Application no: H23/0186/01
Original Applicant: A M Woods
Washway Road
Saracens Head
Spalding
Lincs

Description: Residential development (3 dwellings)

Amendment: Amendments to elevations
Dwg. nos. rem946-02, rem946-03 & rem946-04

**TOWN AND COUNTRY PLANNING ACT 1990
NOTICE OF ACCEPTANCE OF AMENDMENT**

Drawing No: rem 946 - 03

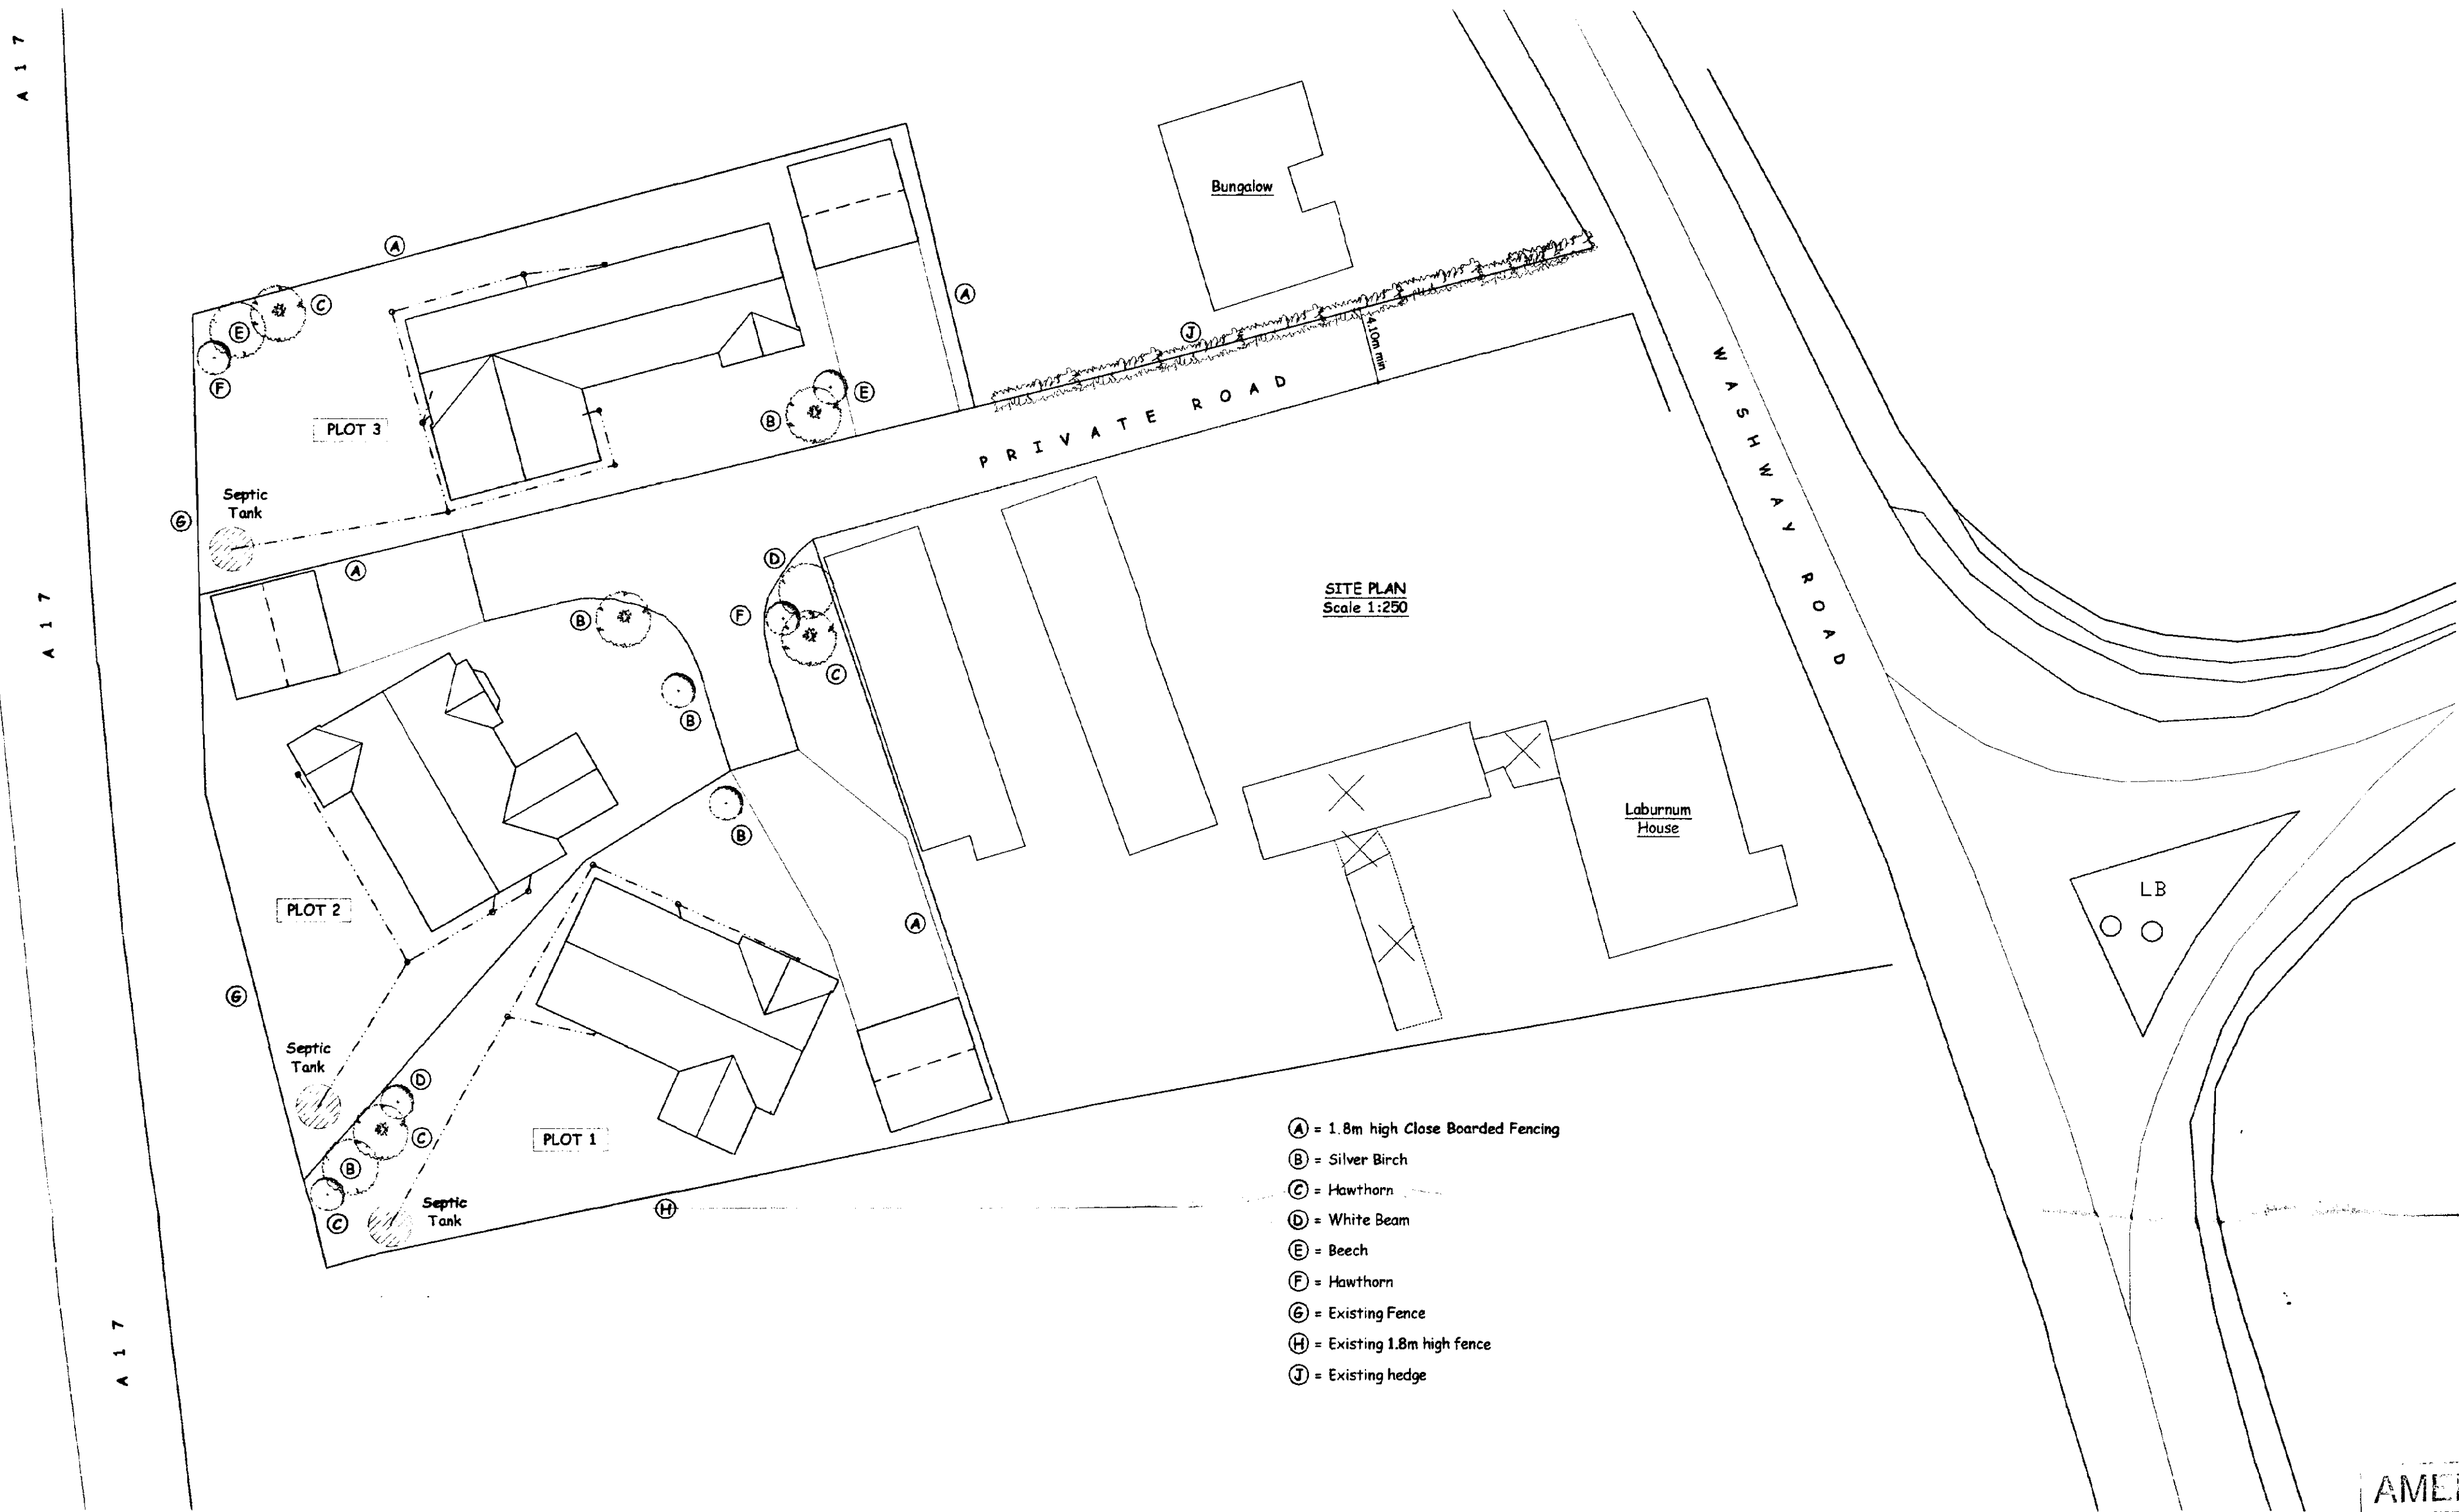
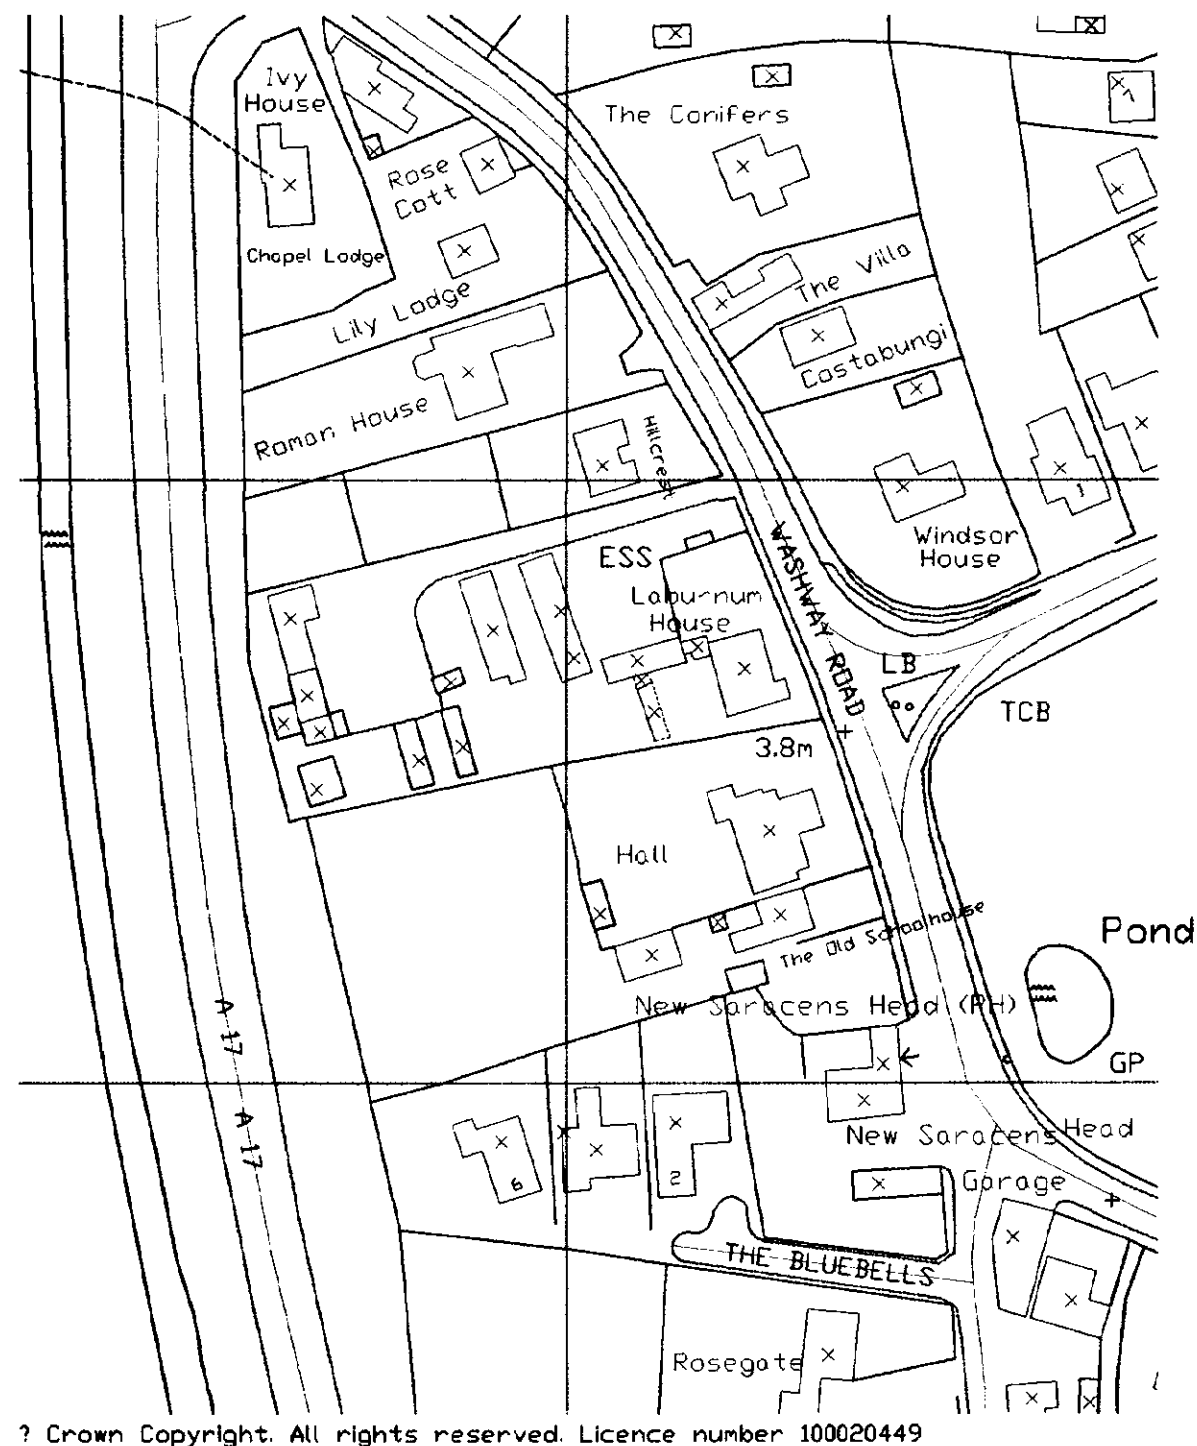
- Feature brickwork plinths have been omitted to all plots
- Feature Parapet Gables have been omitted to all plots
- Removal of all chimneys
- Plot 1 front elevation simplified
